Subject: RE: Y/39/20/RES - Land at Street Buildings

Subject: Y/39/20/RES - Land at Street Buildings

Title:
PLANNING LAYOUT

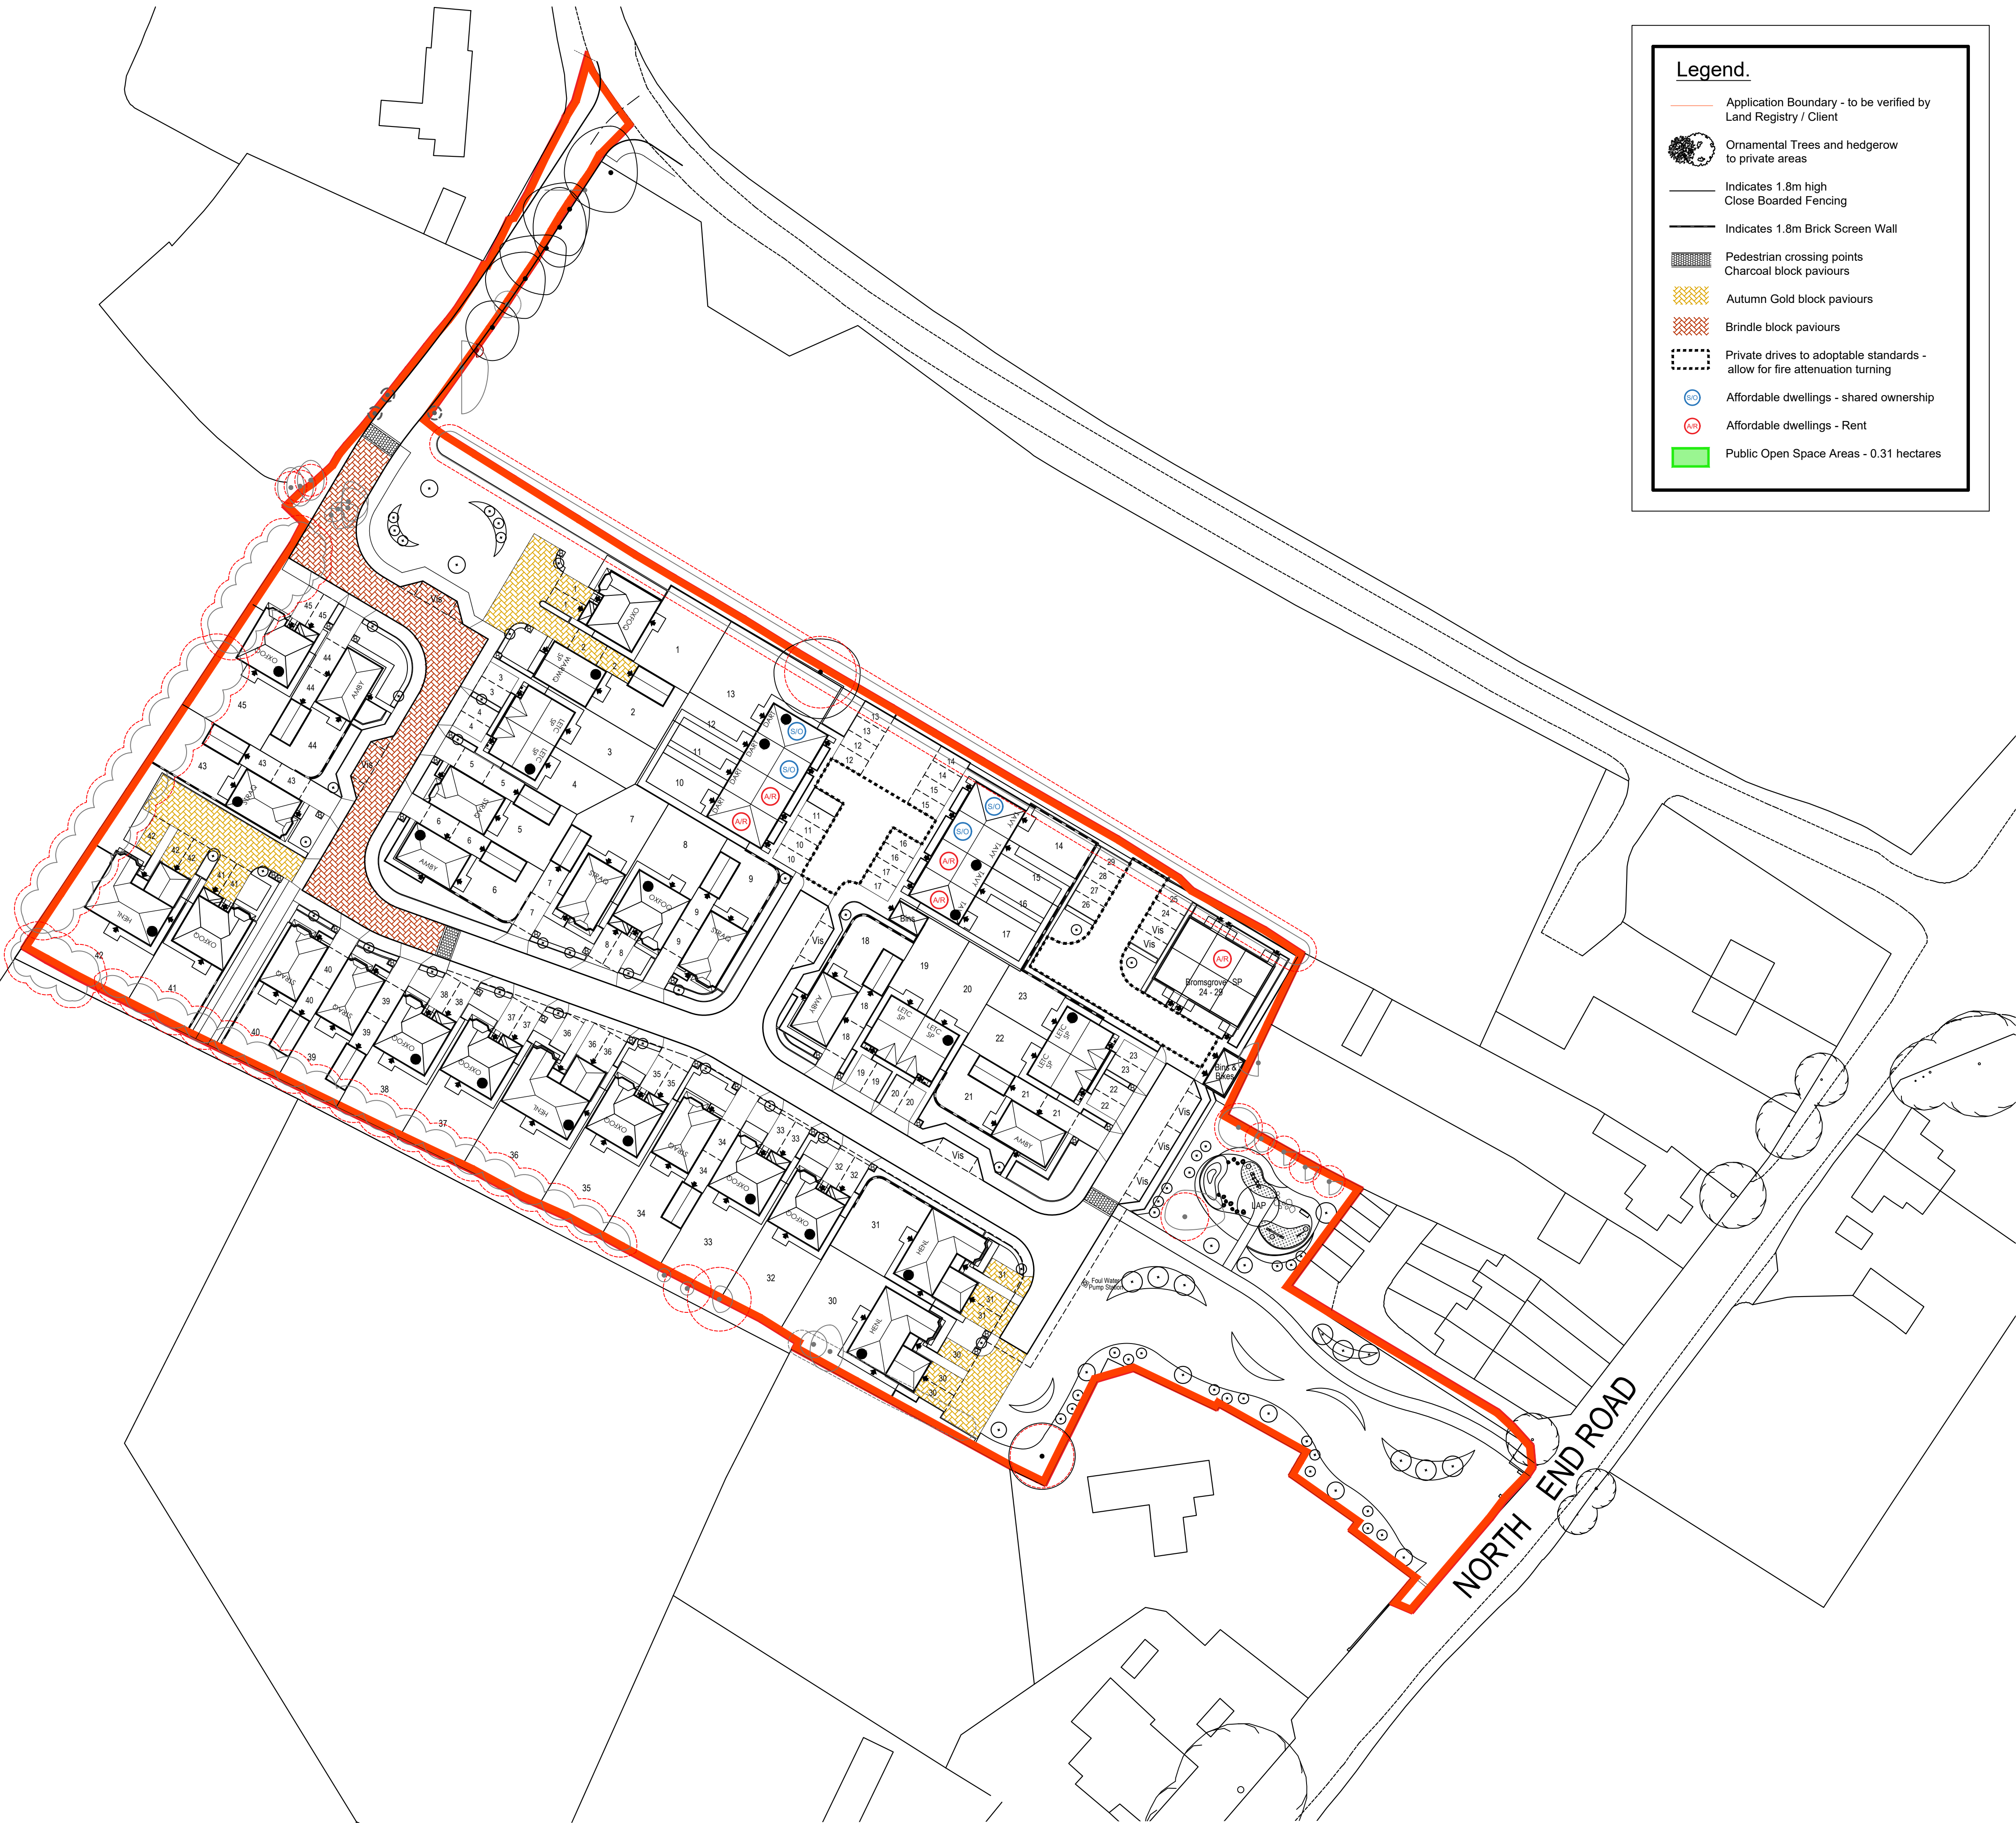
- I wanted to know if it was possible to treat the ends of the brindle block paviour roads adjacent to plots 30 & 42 with landscaping to prevent these from being used as additional parking spaces (i.e. where there is a dead end). Is this space required for turning? If not, then part or all of it could be landscaped to reduce amount of hard surface/soften the streetscene further.
- I appreciate that the retained tree to the N of plot 13 is a constraint to the layout in this area. However, what it results in is a small strip of POS that is relatively inaccessible and may have little usability. I am assuming that it is included in the 0.31 ha POS allocation? If it isn't, could it or maybe the rear half only be incorporated into garden of plot 13? I just think that it either won't get used or will but be used antisocially to detriment of plots 1 and 13.

Also in respect of parking (as per the comments of WSCC Highways below), I have done my own calculation and I make the Parking Need as per the Arun SPD to be **103** based on 2 spaces per 1, 2 or 3 bed dwelling, 3 spaces per 4 bed dwelling and 20% of the total houses as visitor spaces. Your provision would seem to be **107** consisting of 86 allocated spaces, 14.5 garage spaces (garages are treated as 0.5 of a space as per the SPD) & 7 visitor spaces. Assuming I haven't miscounted anything, you would appear to comply overall although there is an individual shortfall in the number of visitor spaces and the number of spaces for the 1b units. I would suggest that the 1B flatted provision may be ok (the SPD allows for flexibility with flats) but that the visitor parking should be increased with an extra 2 spaces
